## **Re: Submission to SSD-62855708 - Botany Waste Management Facility - 2-4 Hale Street, Botany NSW 2019**

We write to object to the proposed SSD. Our key concerns relate to the potential adverse traffic and parking impacts associated with the proposed waste management facility.

Drawing Title
SITE PLAN
 SHEET NUMBER
1220011_A005
 ISSUE
K

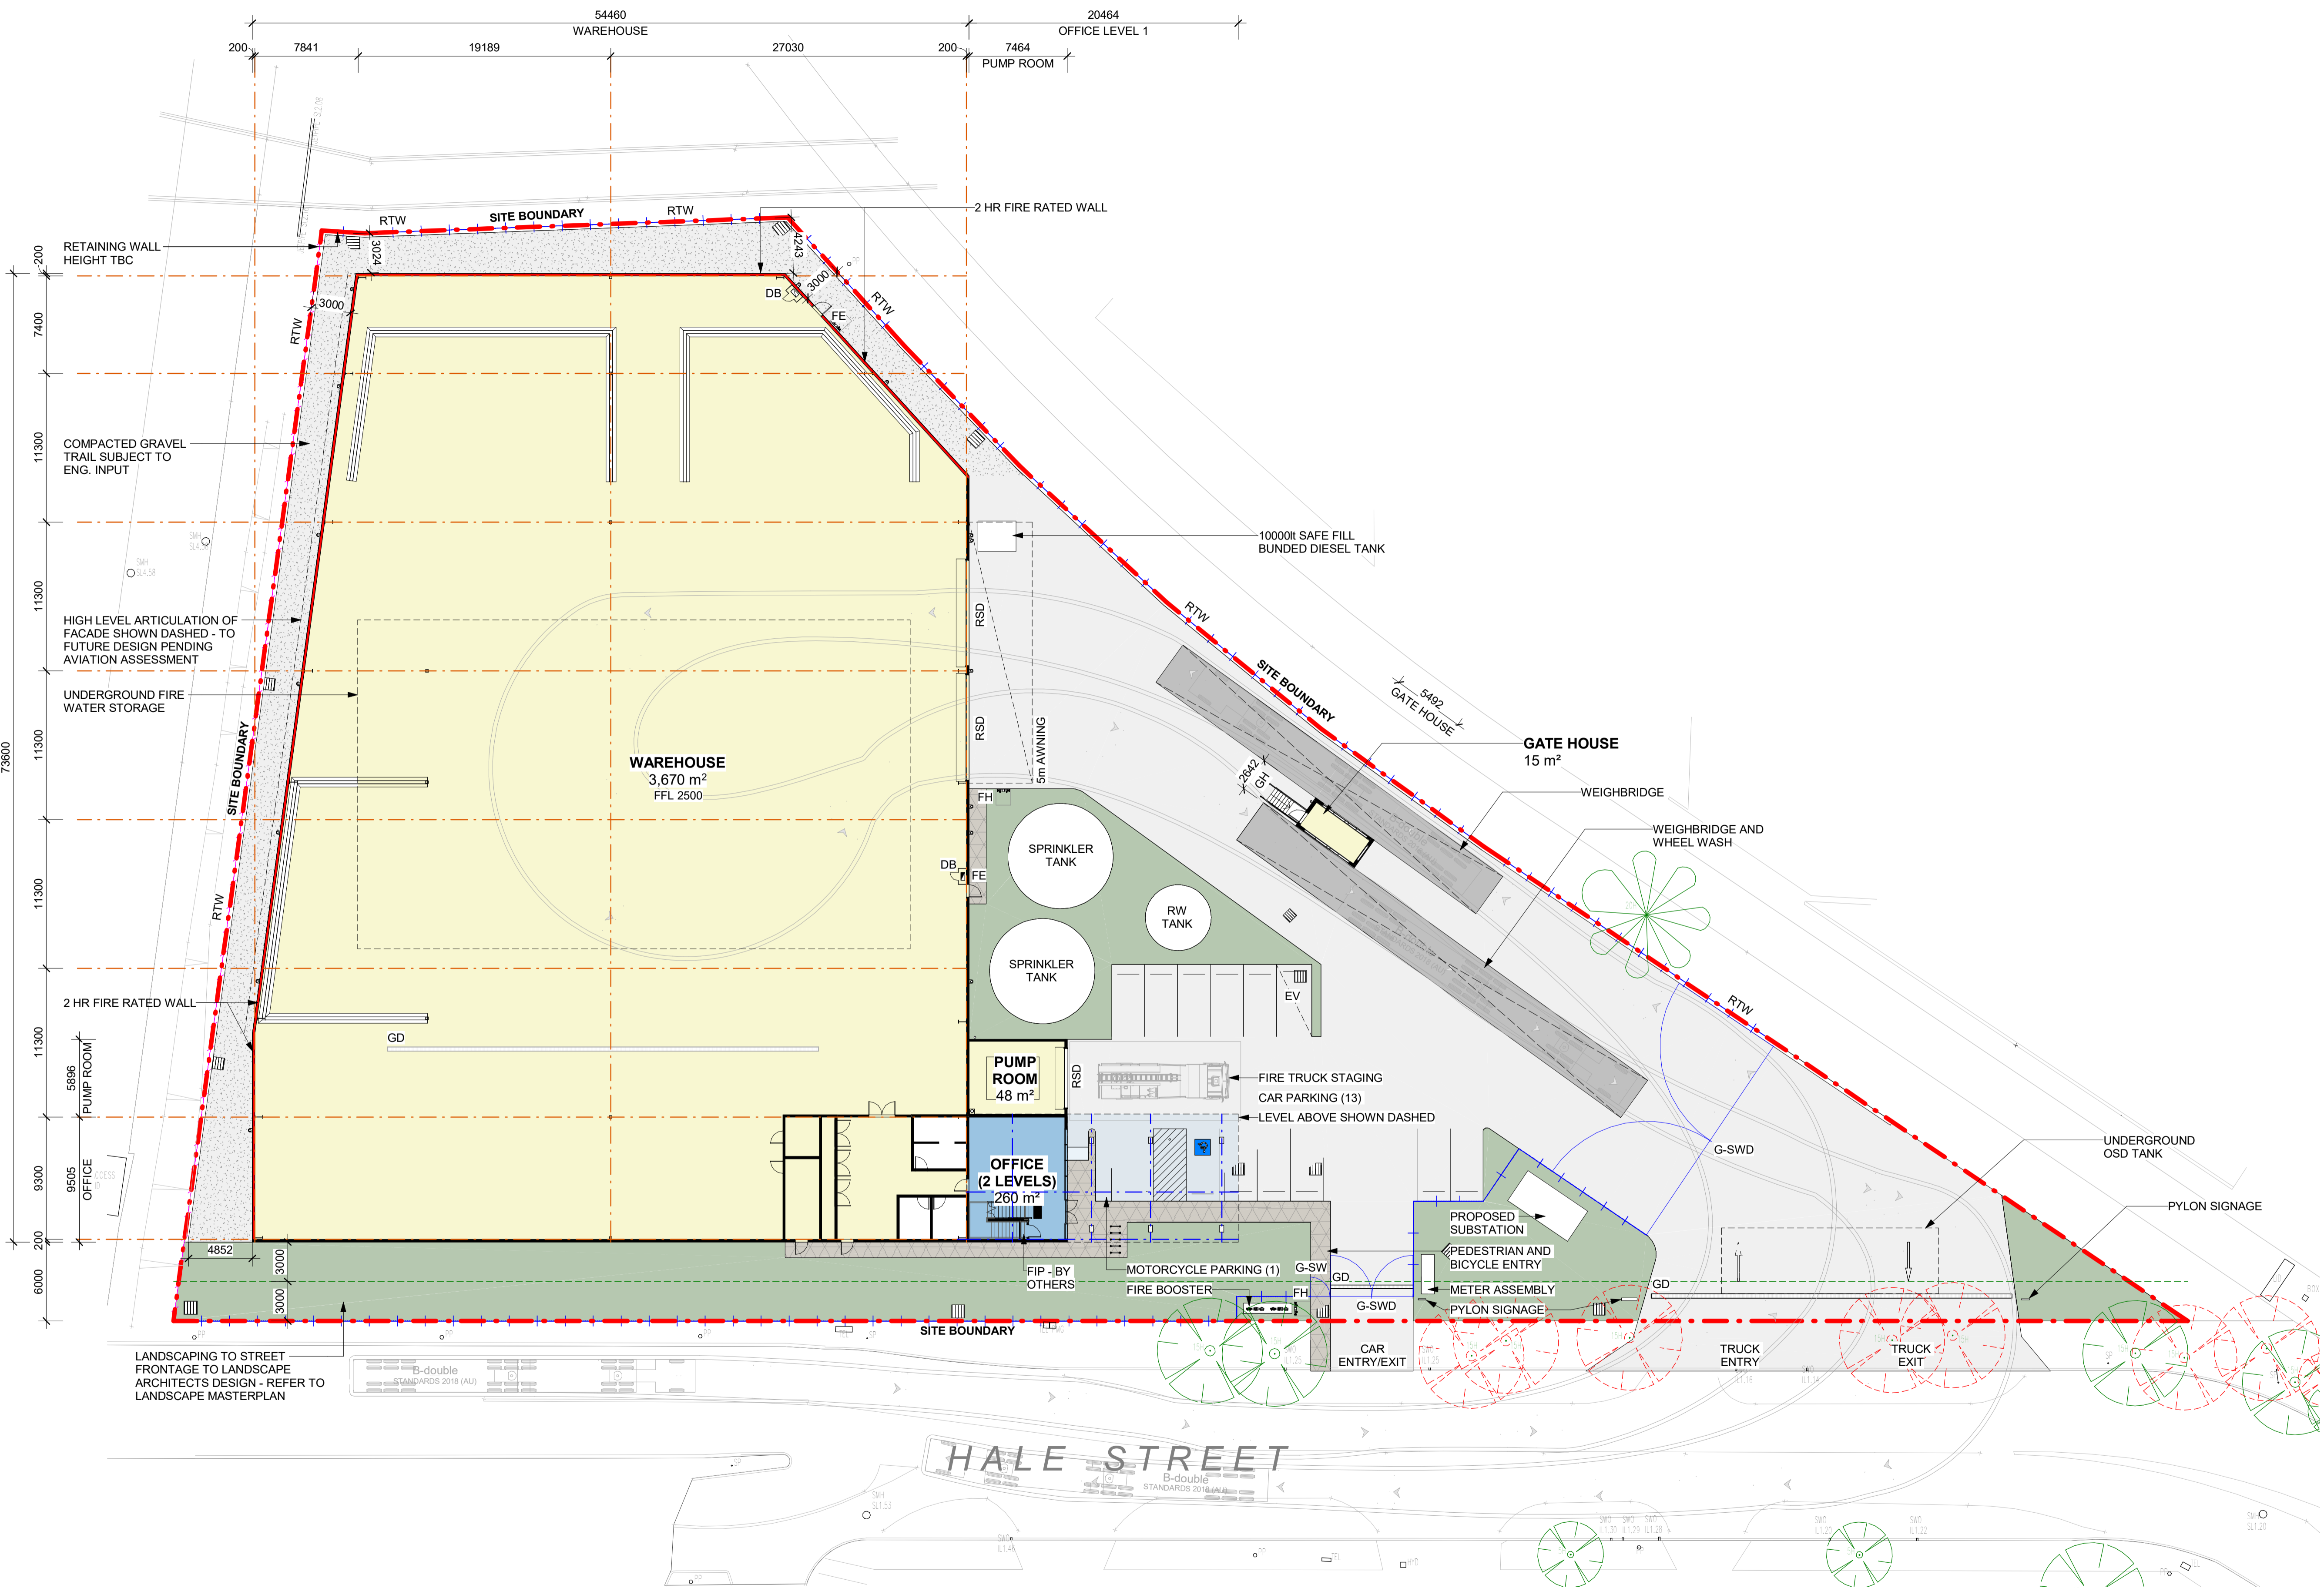
- The western edge of the proposed truck entry and exit driveway is approximately 40m away from a significant rise in the road level of Hale Street to the west – vehicles will be accelerating down the slope towards the site;

- The eastern edge of the proposed truck entry and exit point appears to be approximately only 15m from the roundabout intersection of Luland Street and Hale Street;

- The proposed truck driveway is opposite an existing driveway at 12 Luland Street and is diagonally opposite two more driveways at 270-29 Hale Street and 31 Hale Street;

Queuing Diagrams

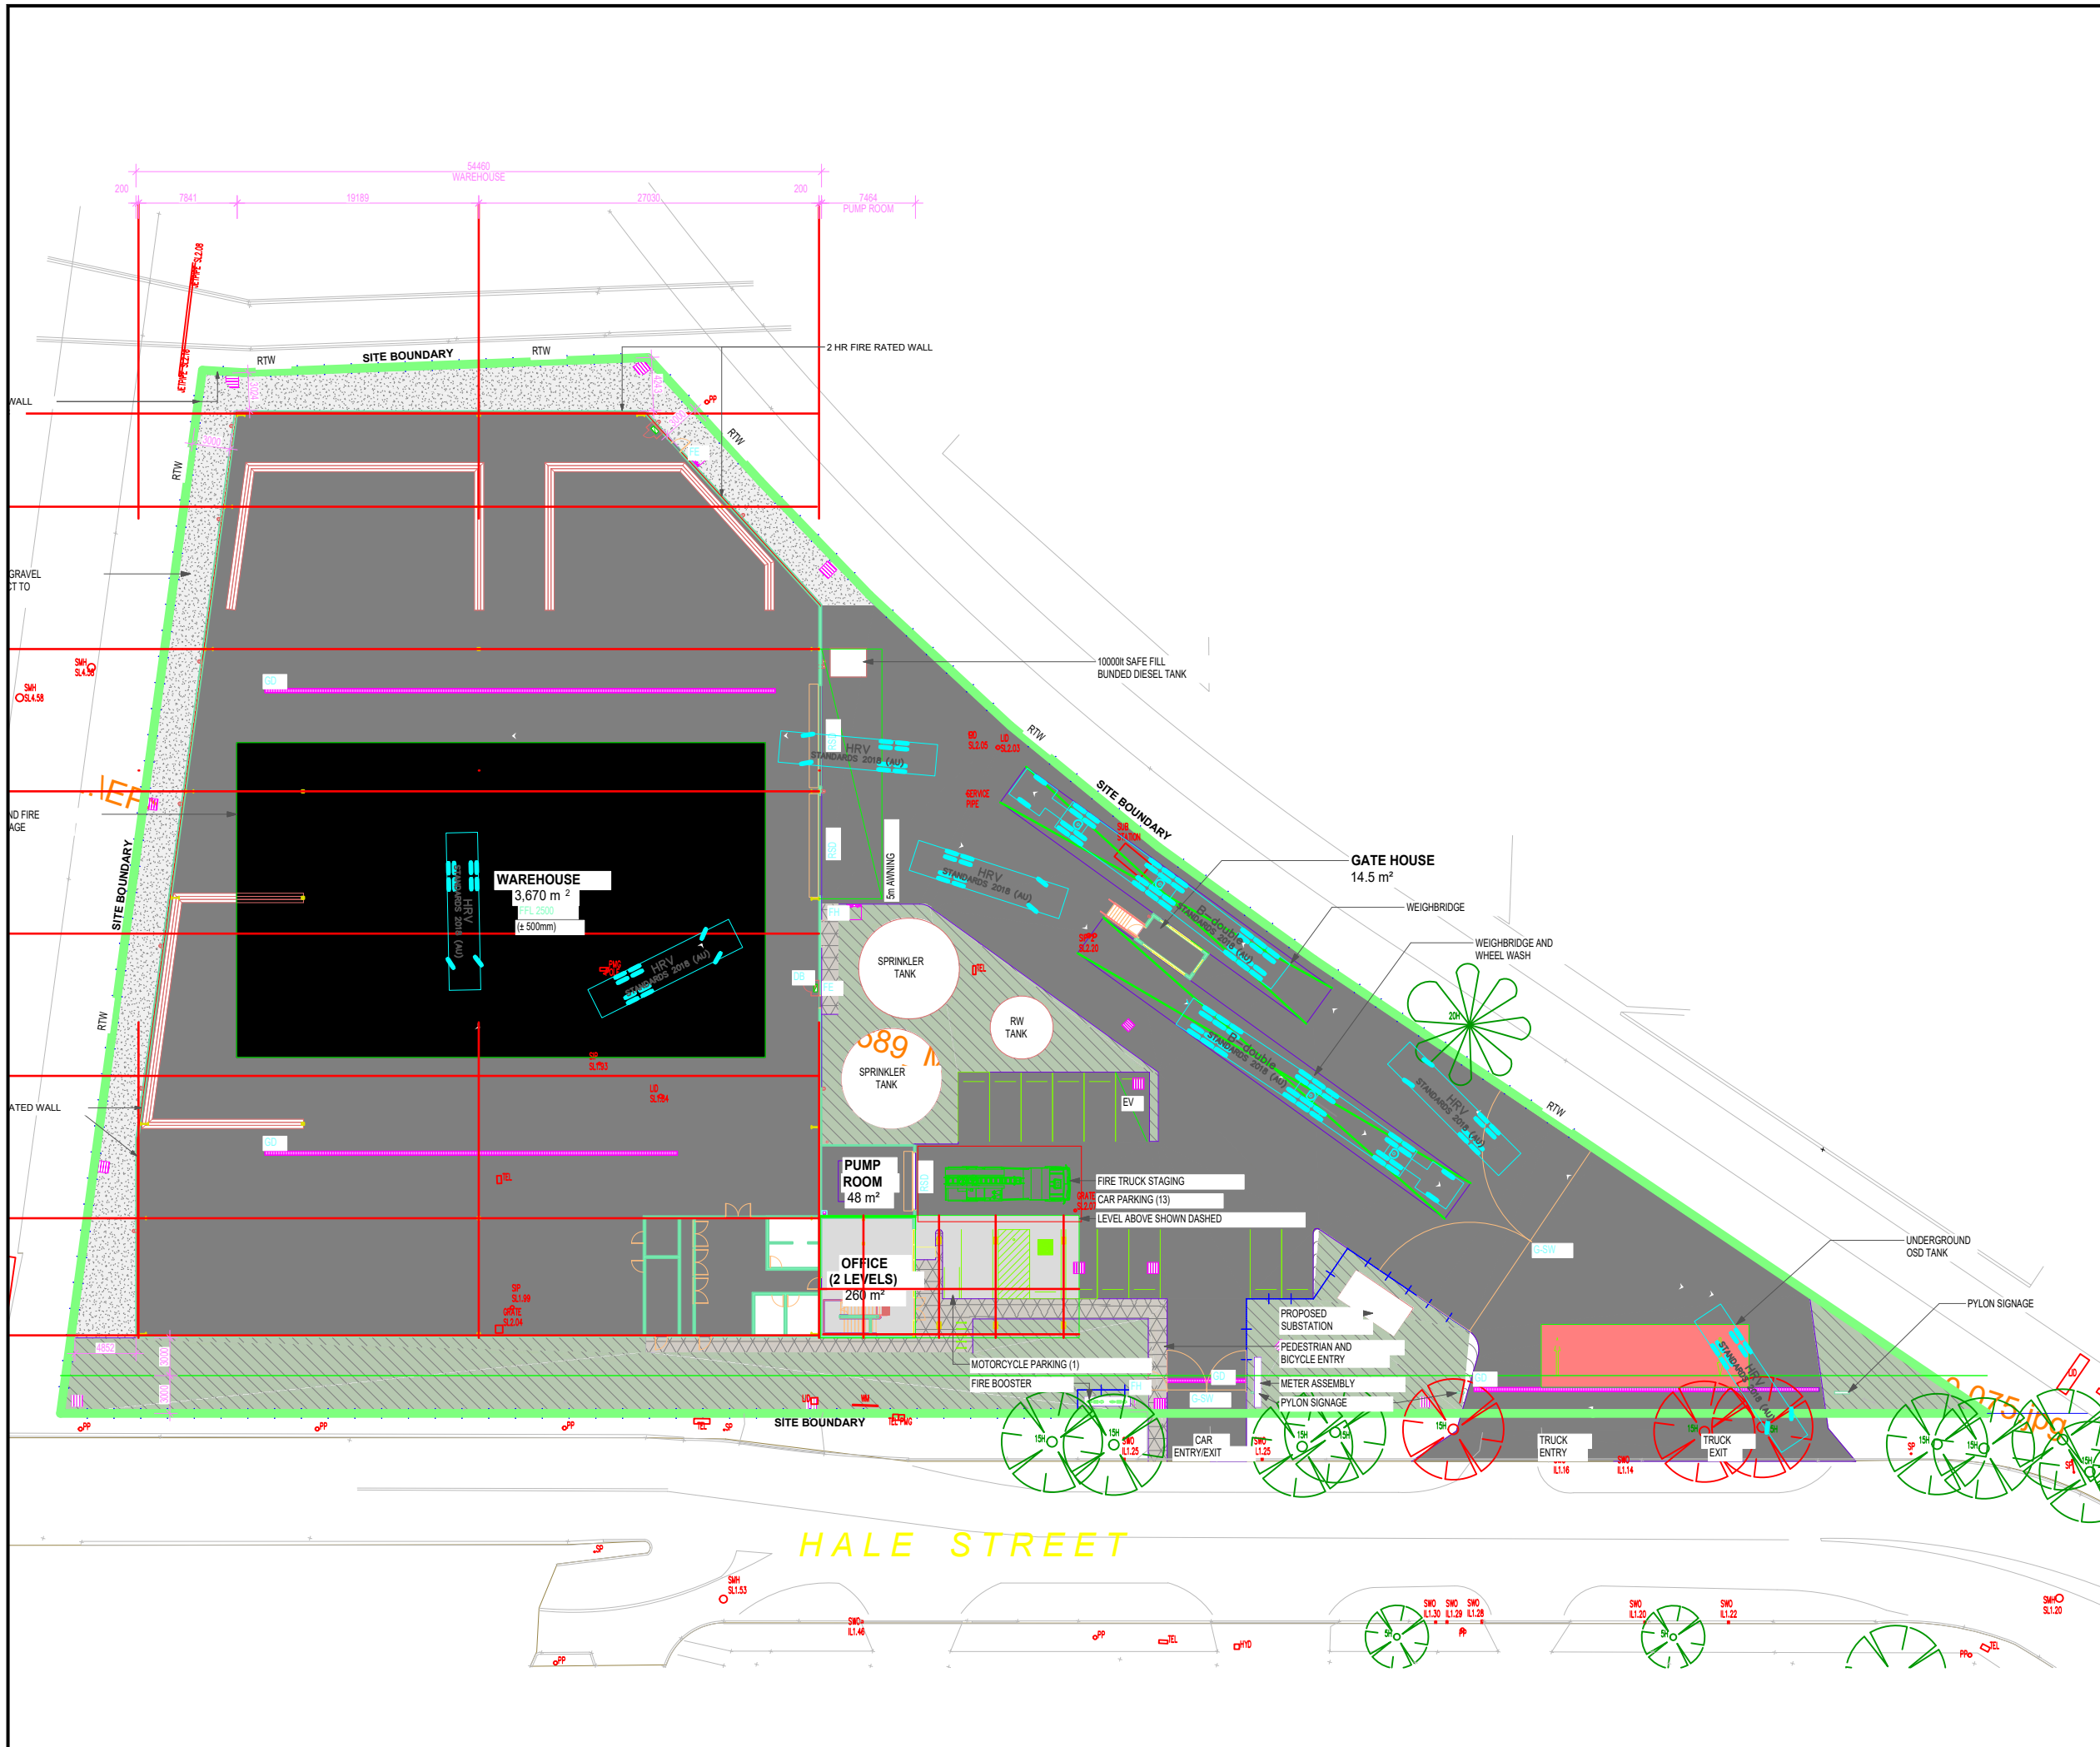
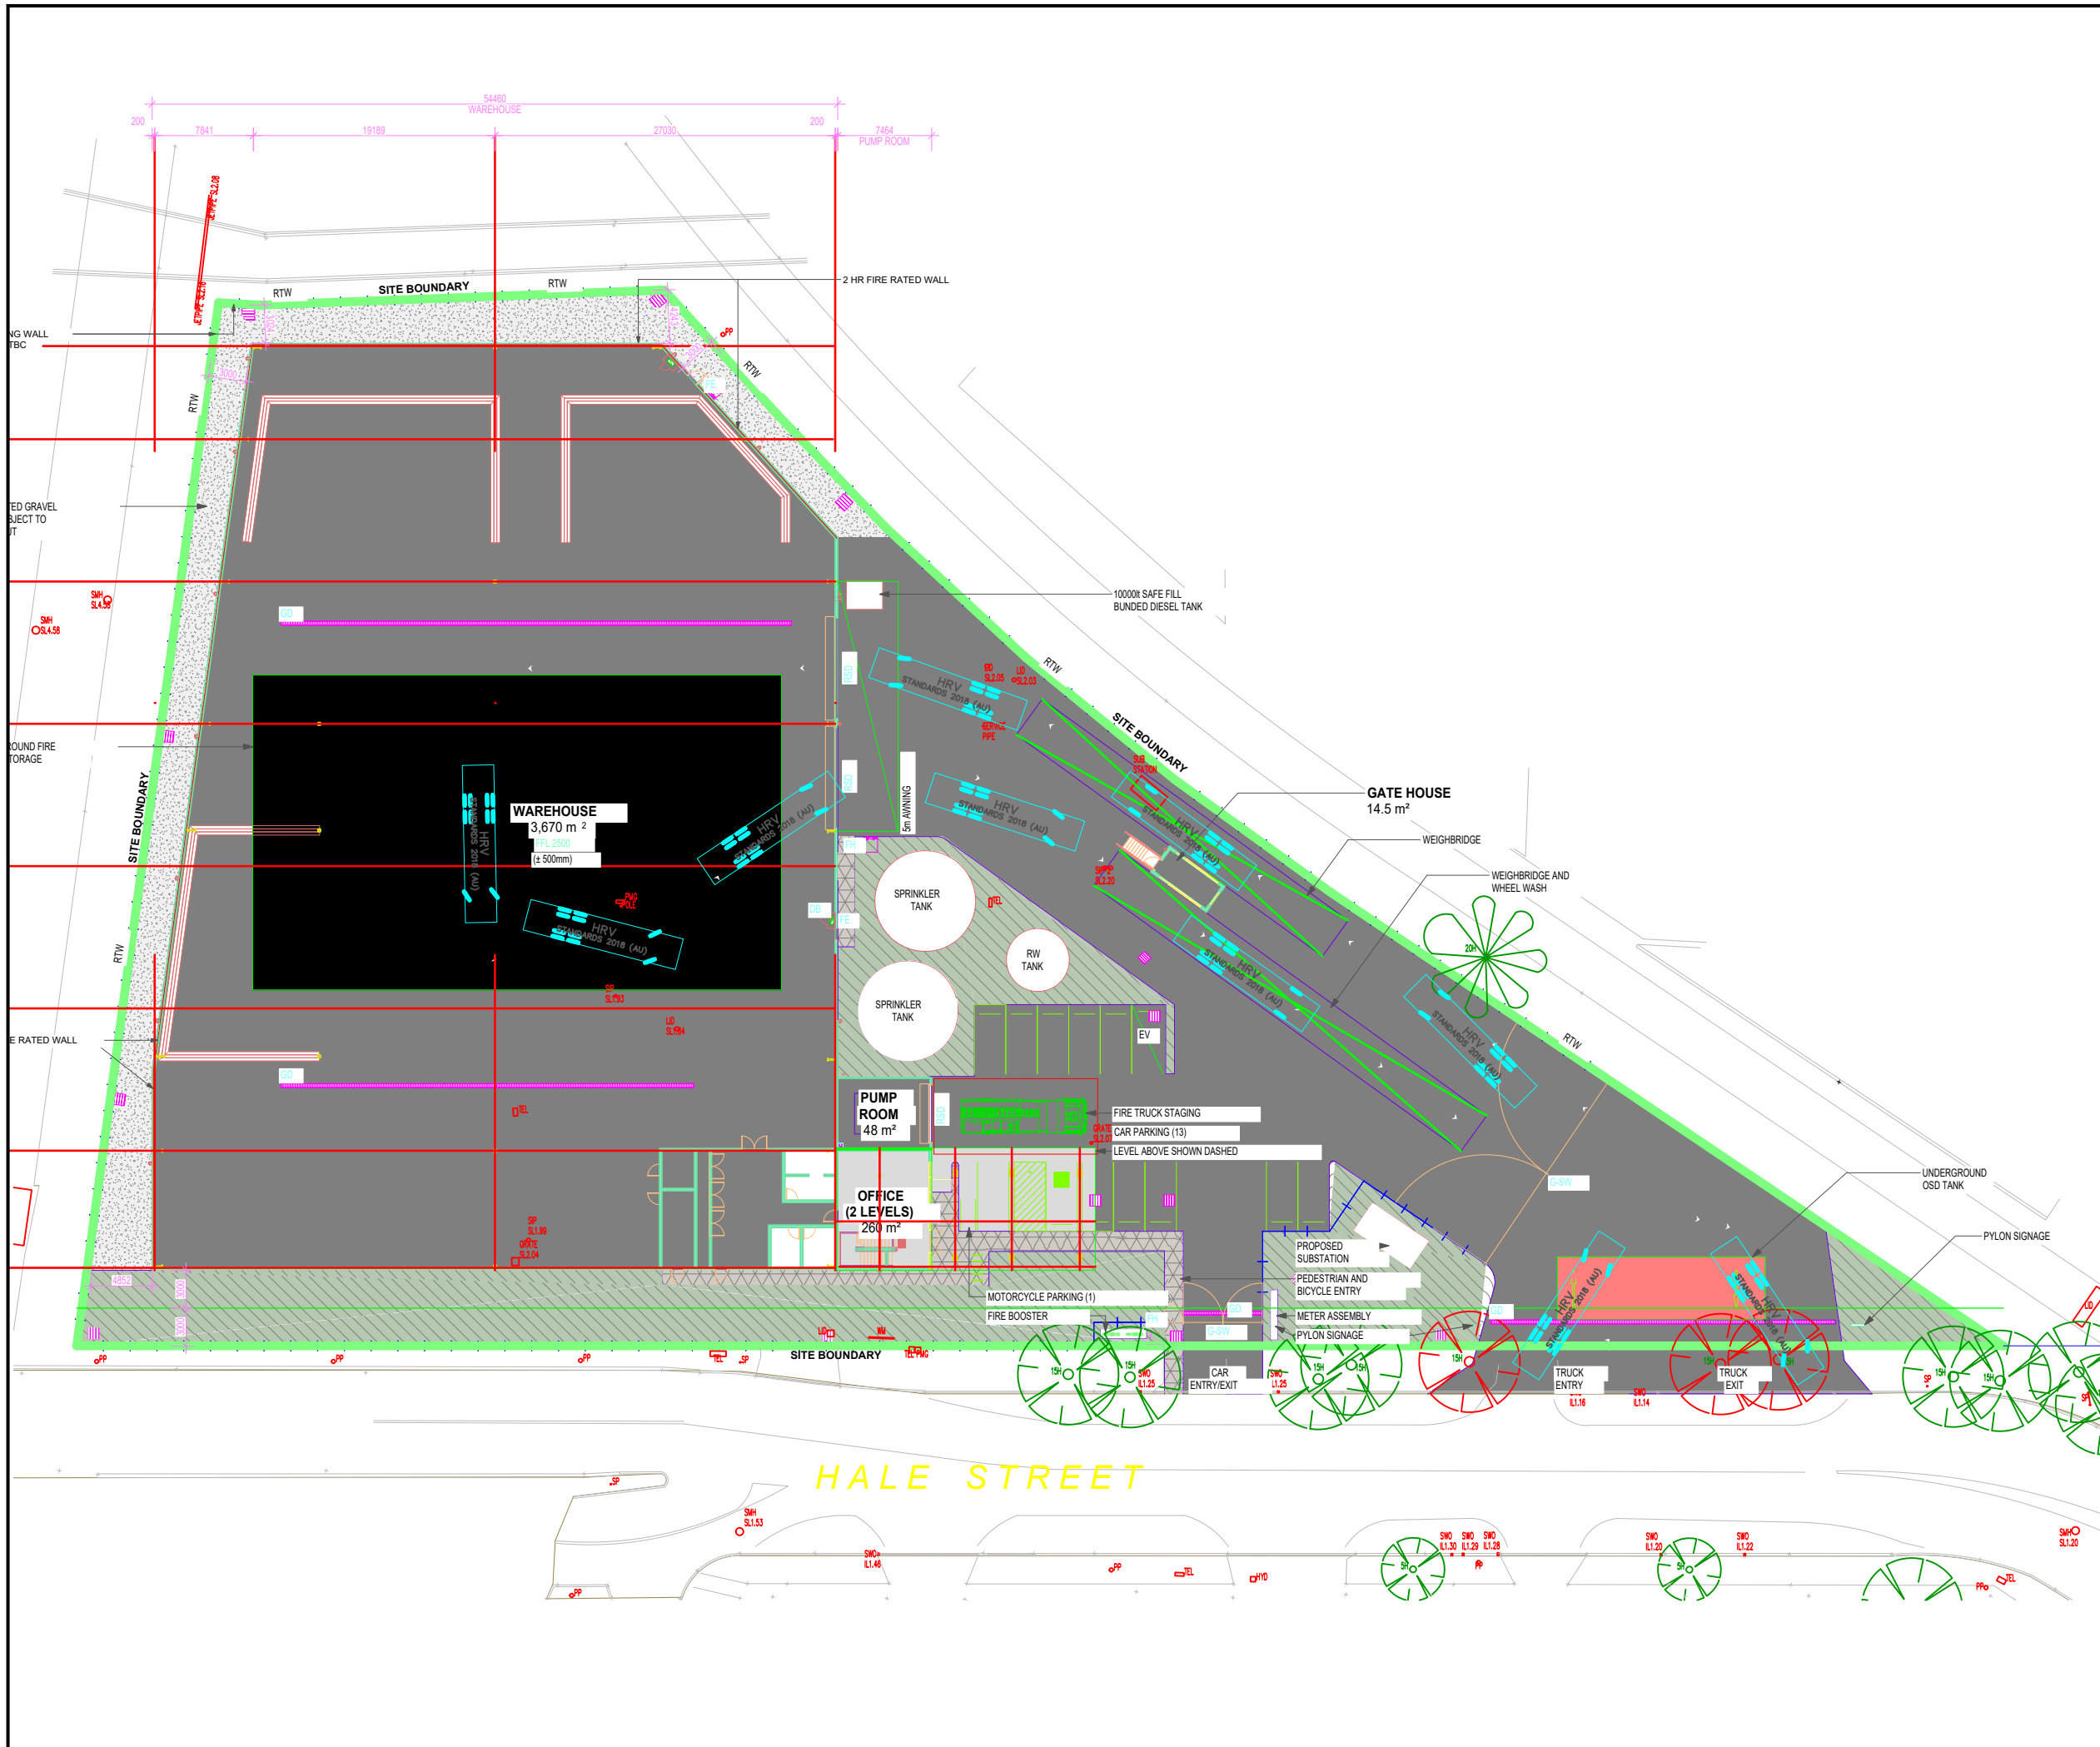
- The proposed queuing arrangements appear to be reliant upon management by on-site staff – if so how will this be undertaken and what happens if more than 5 heavy vehicles arrive at the site at any given time (given the site has a queuing capacity for 5 heavy vehicles only)?

In the event that more trucks arrive at the site and there is insufficient queue space on site, what will be the path that heavy vehicles take within the local road network to enable them to circle and return to access the site?
